STORMWATER MANAGEMENT PLAN CHECKLIST

~~PPR 2034~~ **PPR219**

EL PASO COUNTY, STATE OF COLORADO GRADING & EROSION CONTROL PLAN

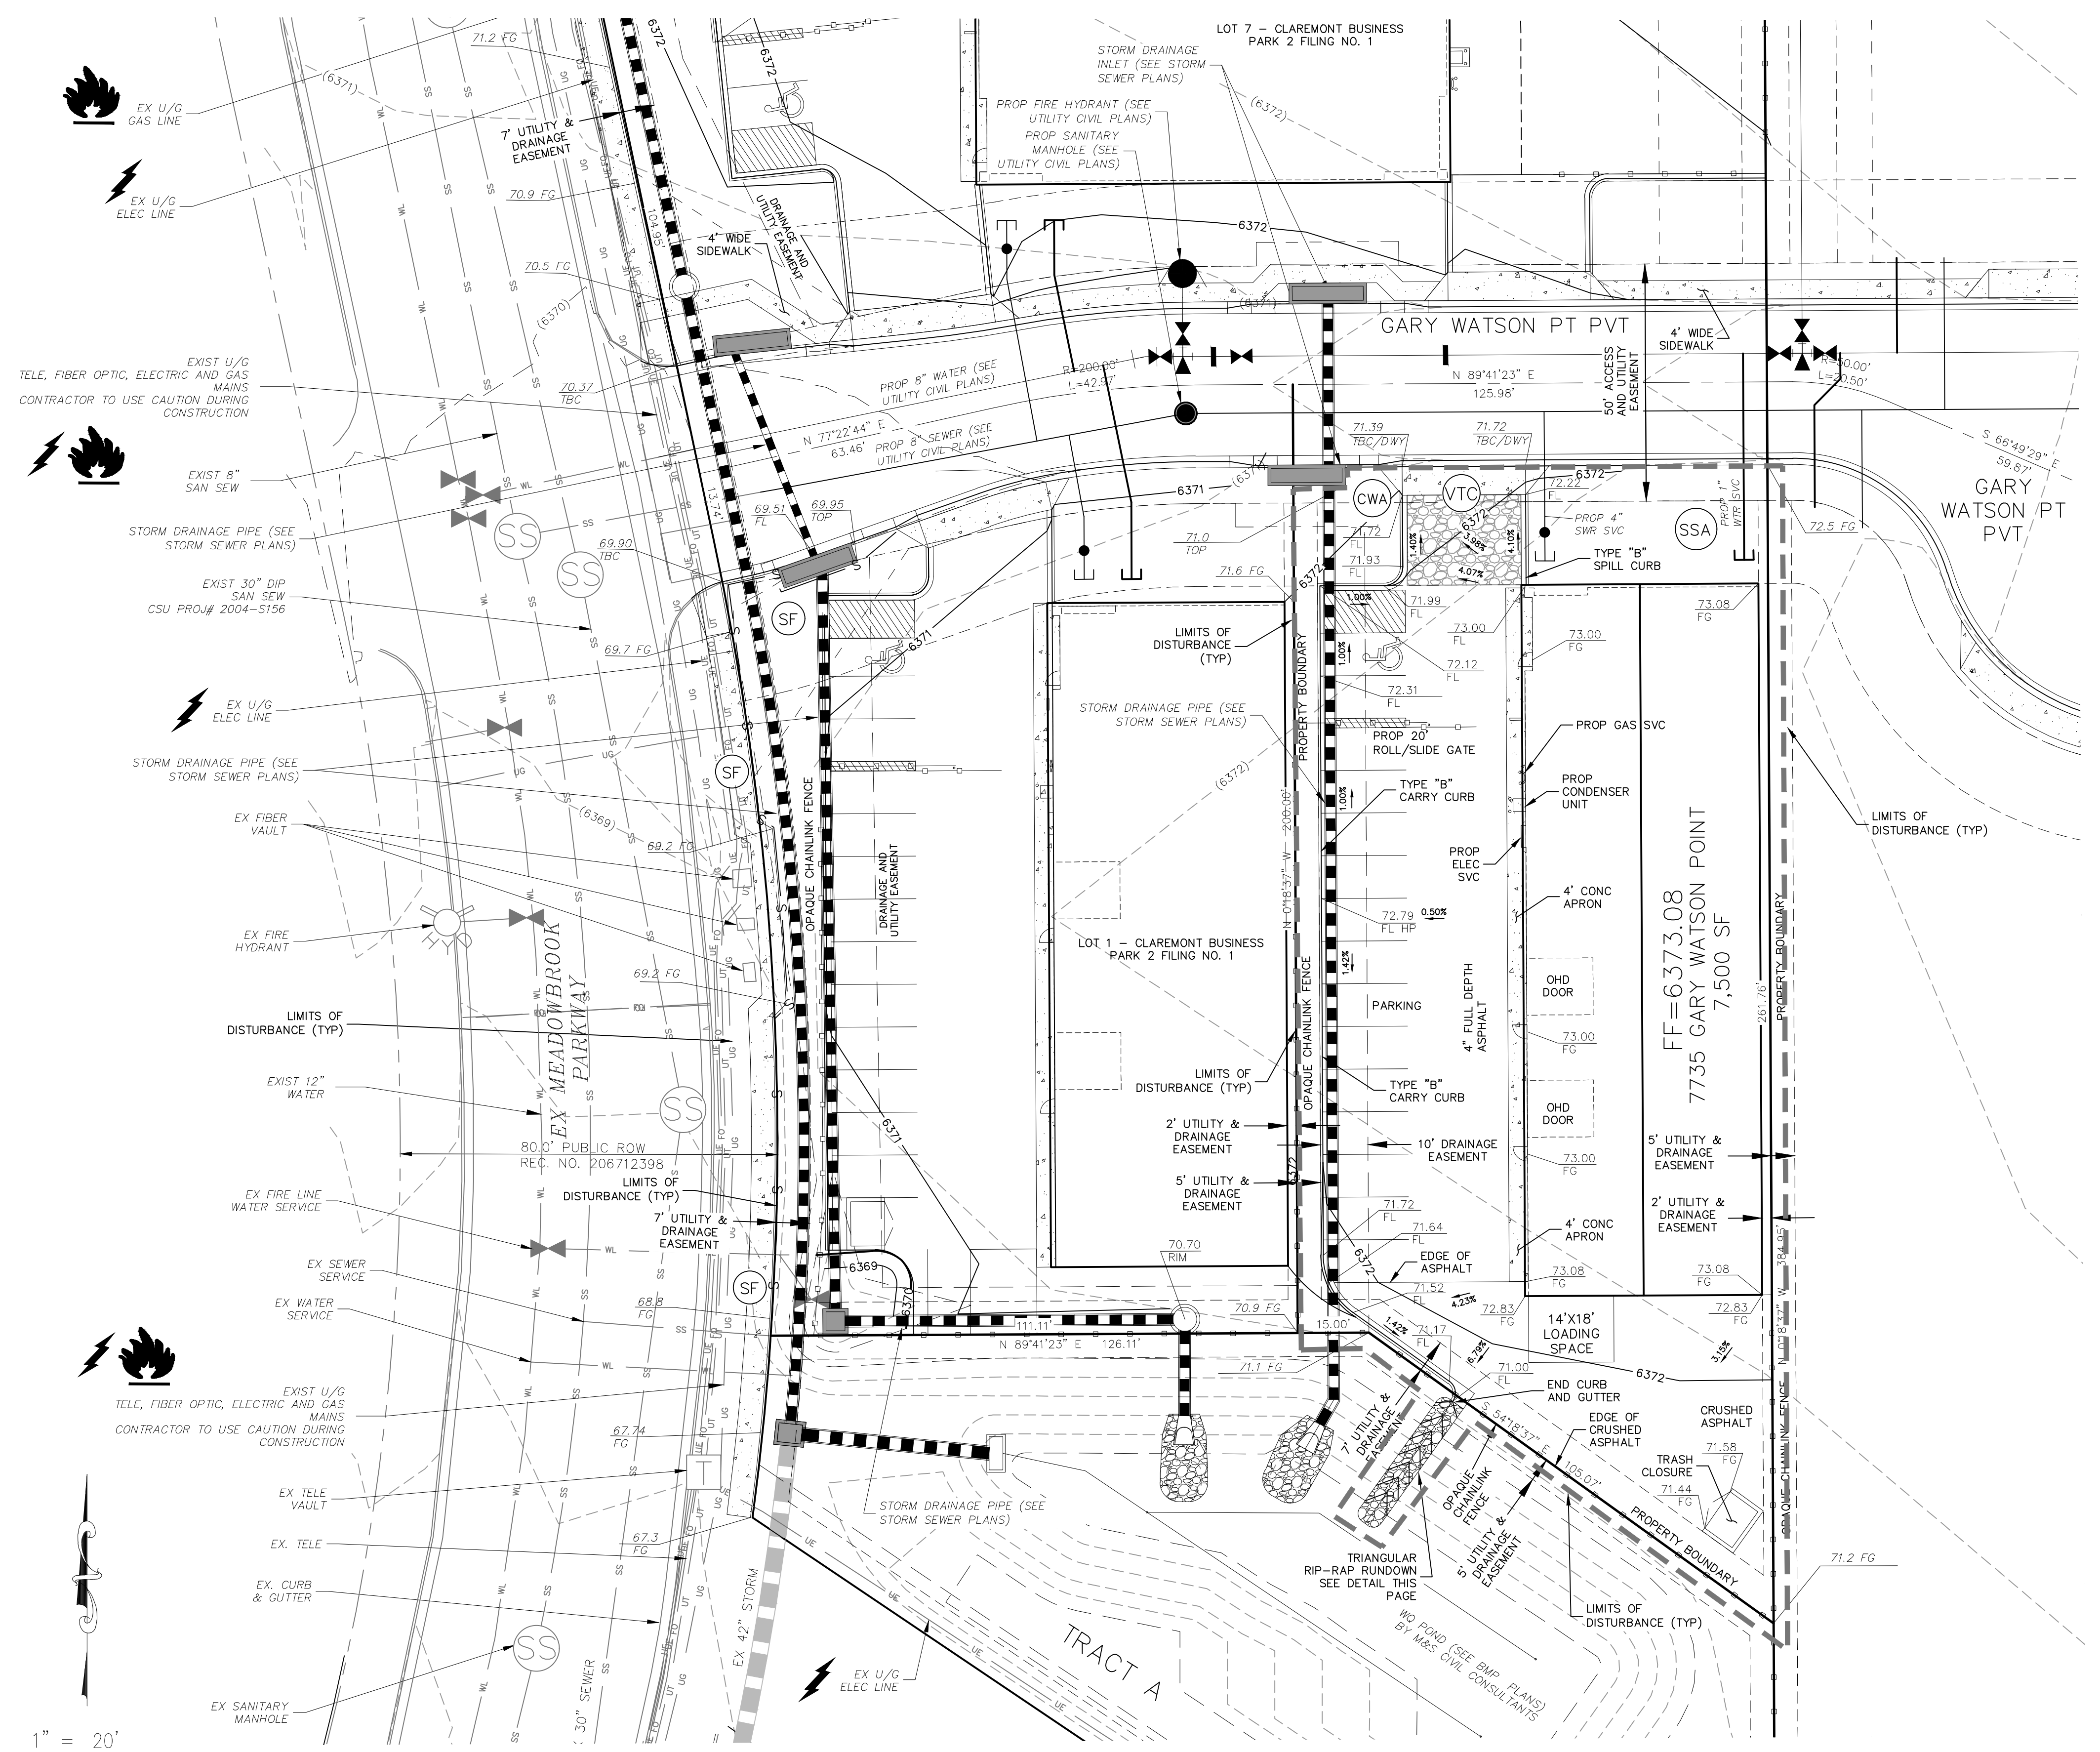
Applicant	PCD
b	Item 17f- No Asphalt Concrete Batch Plant are needd for the project		
<div style="border: 1px solid black; background-color: #f4a460; padding: 5px; display: inline-block;"> 17d - cut/fill was completed under EGP204 </div>			
c	Item 26 - This project has no reliances for control meadusres by other entites
